HINCKLEY NATIONAL RAIL FREIGHT INTERCHANGE

*Summary of Written
Representation (ref. HRFI-
20040018) on behalf of Blaby
District Council in response to
Tritax Symmetry (Hinckley)
Limited submission of a
Development Consent Order (ref.
TR05007)*

Deadline 1 - October 10, 2023

M69-A47 LINK ROAD GENERAL ARRANGEMENT

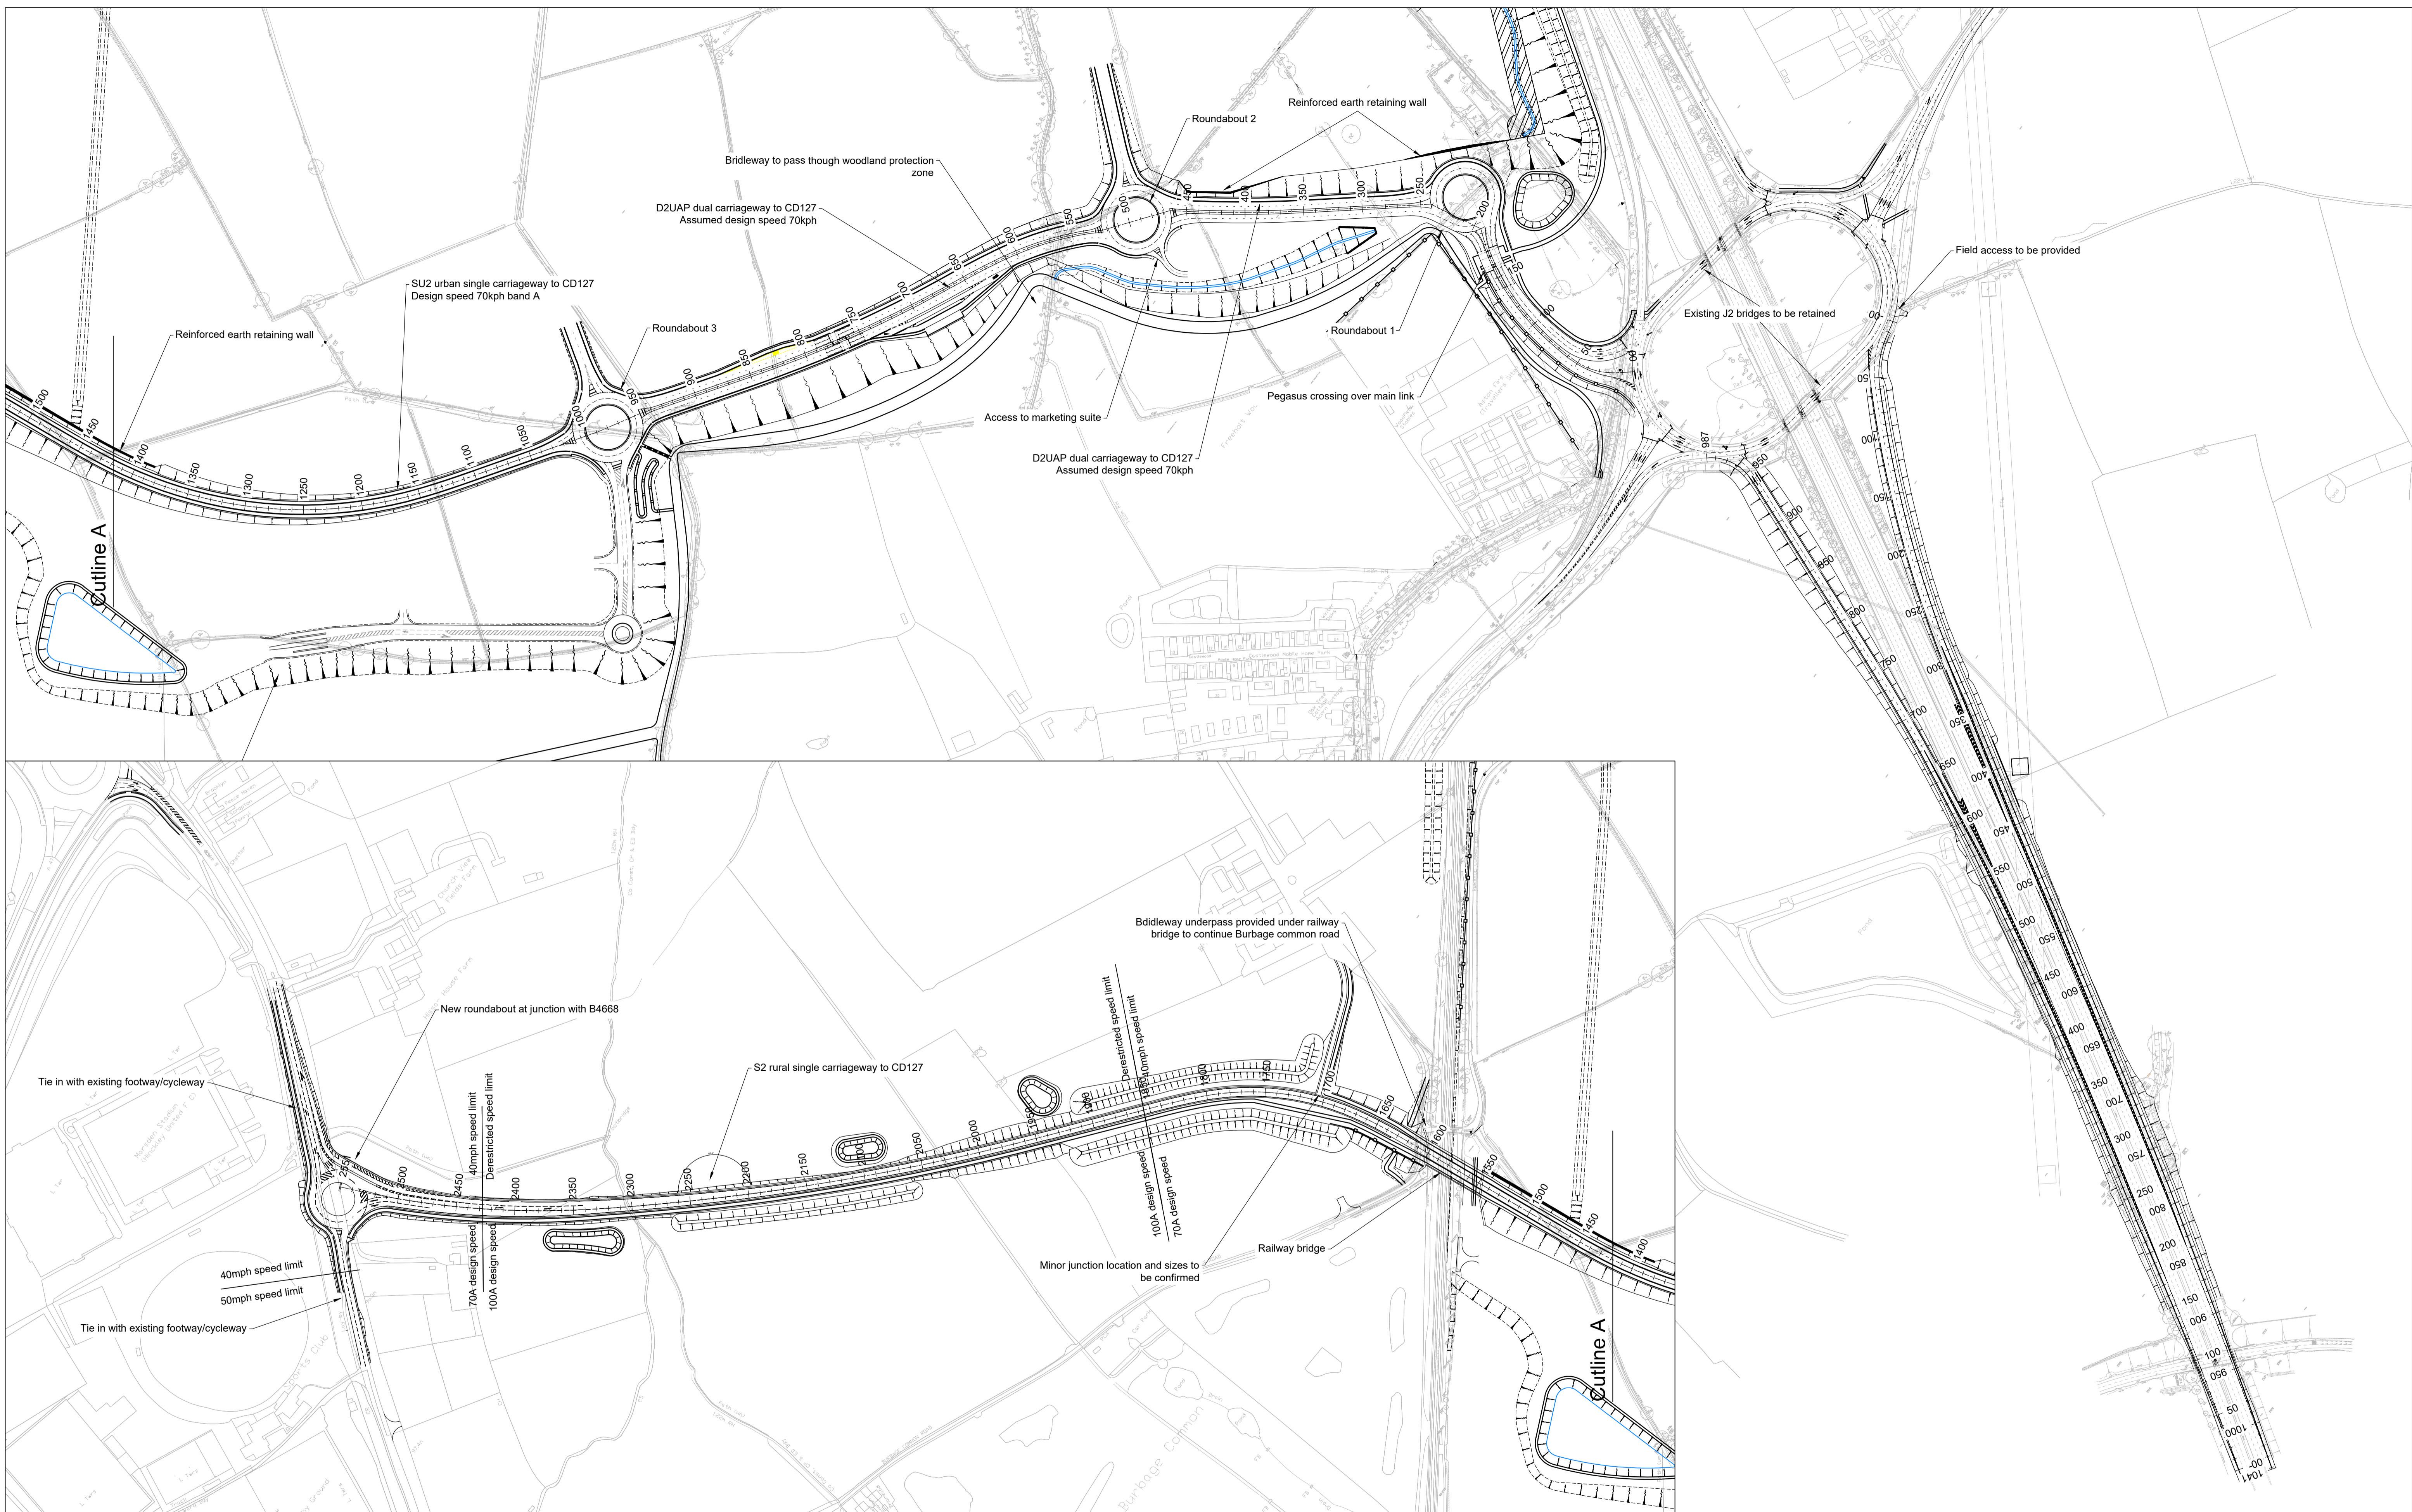
- 3.3. BDC raised concerns in respect of the layout of the Proposed Development, with any tugmaster movements needing to cross the A47 link road.
- 3.4. BDC consider that the link road needs to be expressly secured through the description of works at Schedule 1, Part 1 to the dDCO.

### **Narborough Level Crossing Traffic Modelling**

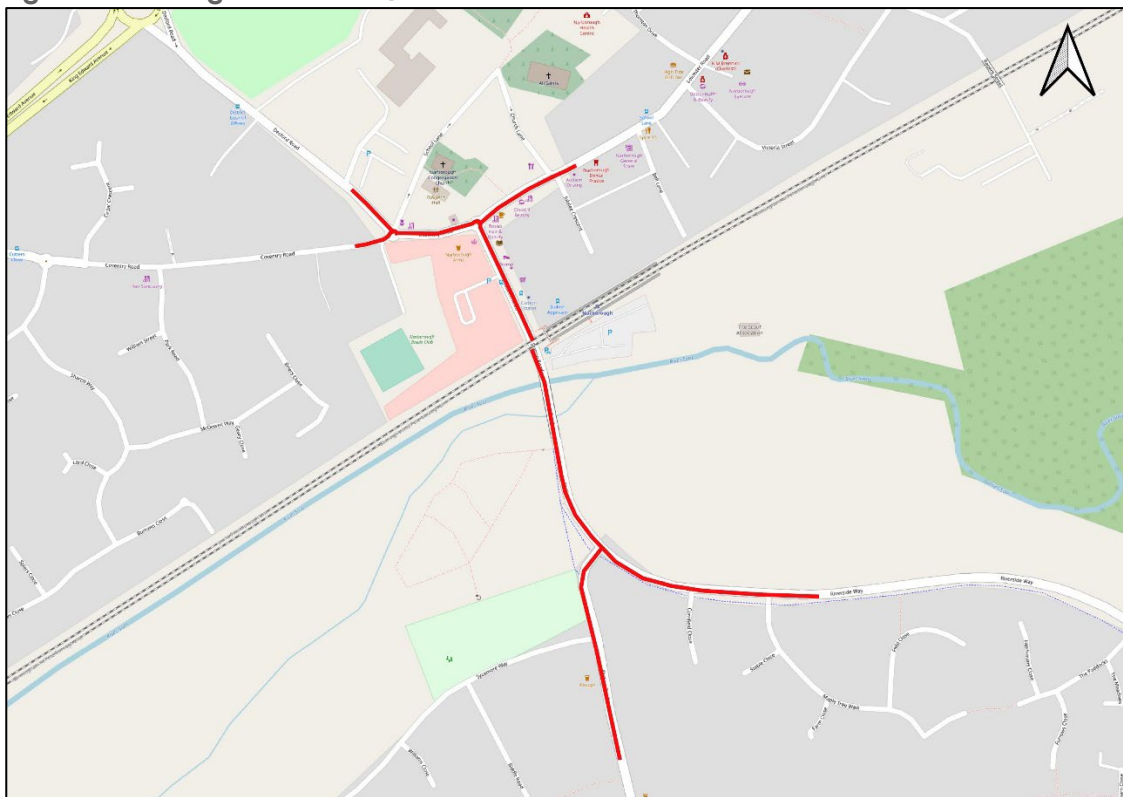
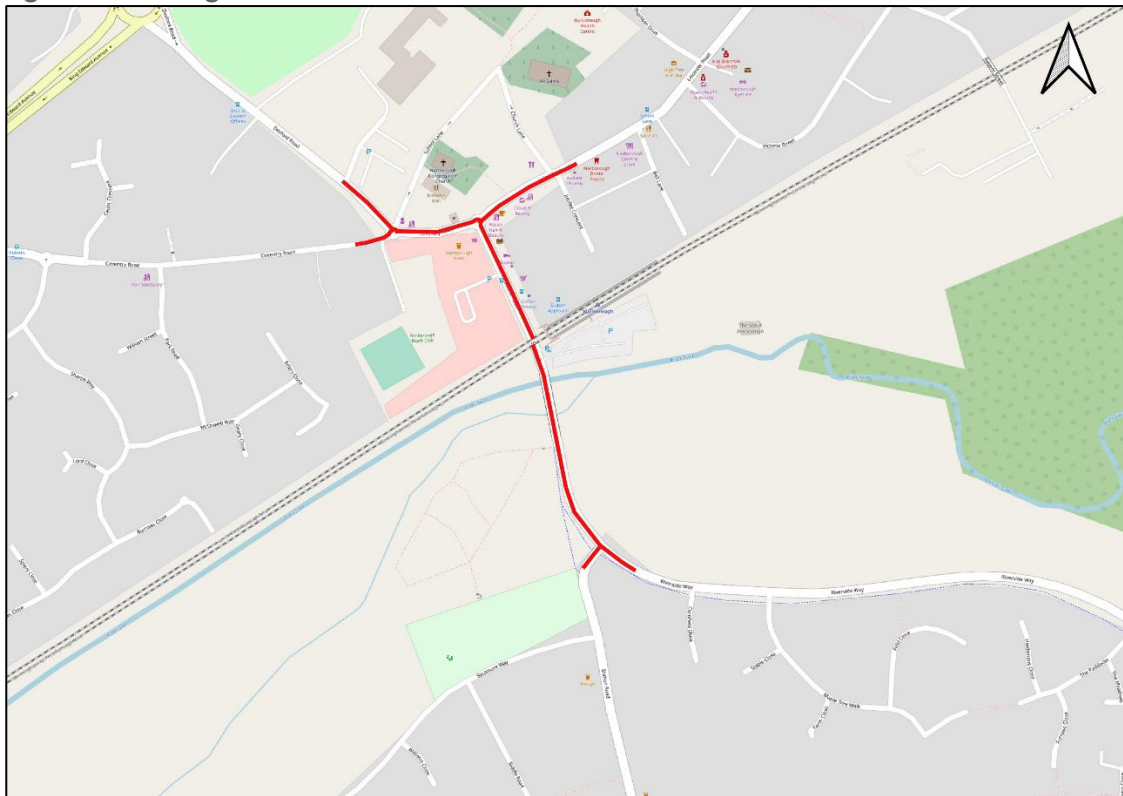
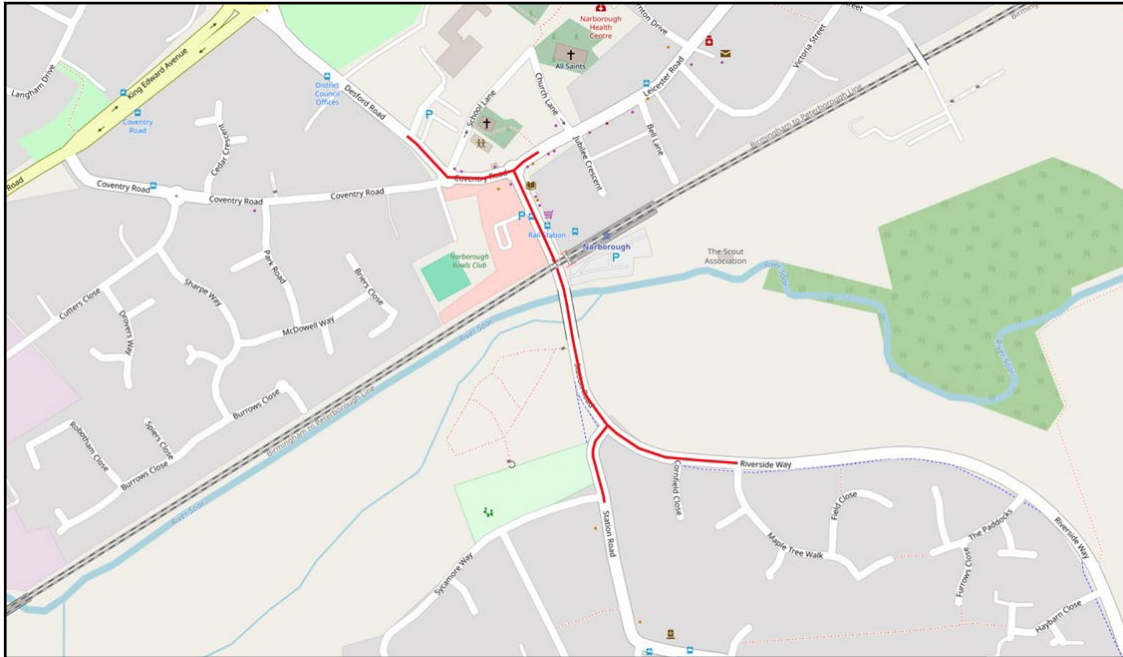
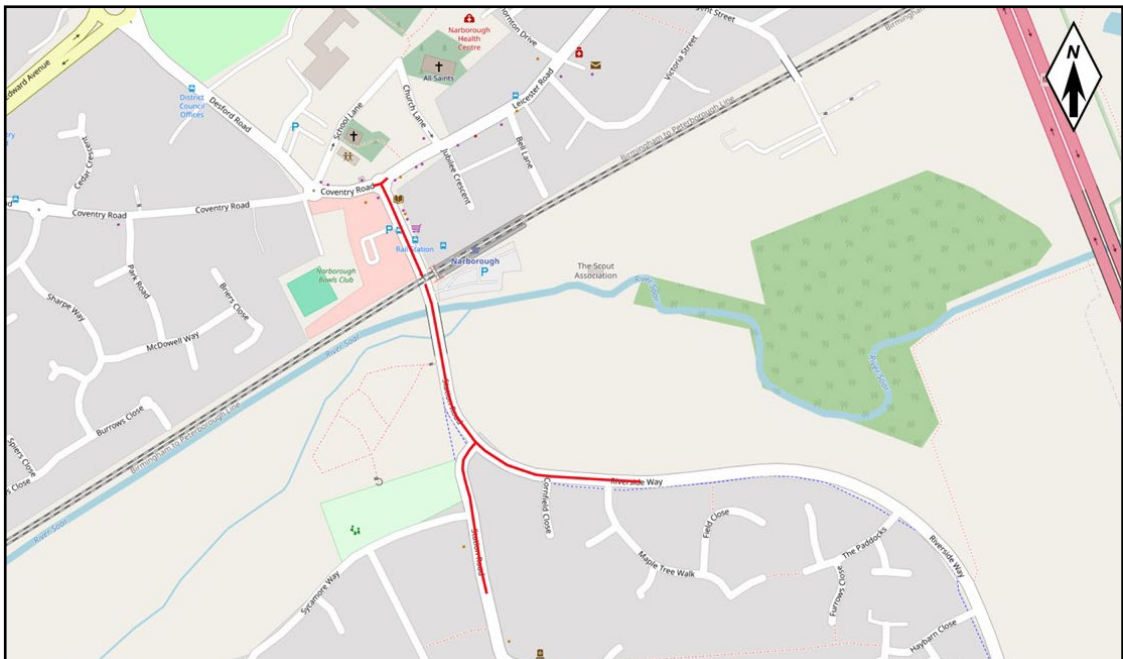
6.10. BDC considers there are significant deficiencies in the Applicant's assessment of the traffic impacts of the downtime of the level crossing. Therefore, the Applicant should be required to carry out further assessment work.

10.3. The air quality in respect of queueing traffic as a result of Narborough Level Crossing Barrier down time has not been assessed.
